Application No: AW/133/22/HH
Site Address: 15 The Fairway Aldwick PO21 4ES
Description of works: Erection of single storey side extension including separate porch following demolition of existing side extension. This application may affect the character and appearance of the Aldwick Bay Conservation Area.

Thank you for your internet representation made on 9th June 2022 which has been recorded as an objection with the comments as follows:

EAST ELEVATION 1

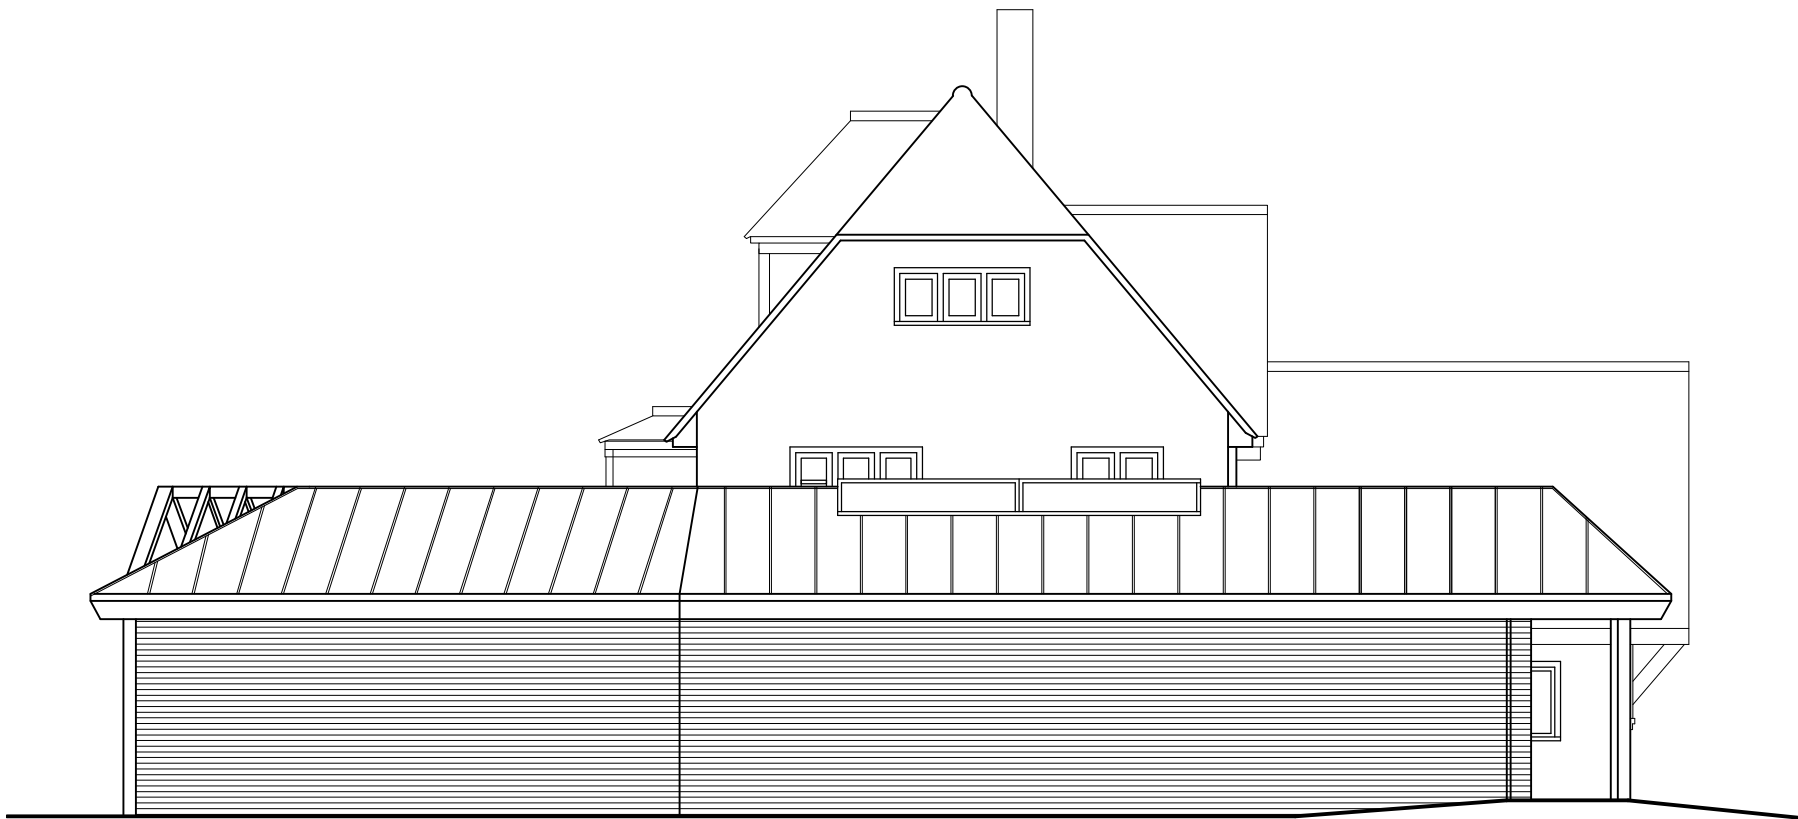
The proposal includes a new single storey side extension along the boundary between Nos 14 and 15 and replacing the existing side extension. From scaling the plans it appears that the proposed extension will be both closer to No 14 and extend over 5 metres beyond the existing side part of the application property and on the site boundary rather than slightly inset from it. It will also extend forward of the existing side part. The height to eaves will be similar - around 3m as scaled - but the ridge will take the overall height to closer to 4.8 metres.

No 14 is positioned at an angle to the boundary with No 15. The proposed extension would be approximately 4.25m from the kitchen windows of No 14 at the closest point and 5.5m from the living room windows.

The proximity of the proposed extension to those windows will inevitably result in a loss of amenity to No14 by reason of the increase in the sense of enclosure. The view from the kitchen will be an unrelieved brick wall for the whole length of the boundary opposite. It will be very oppressive.
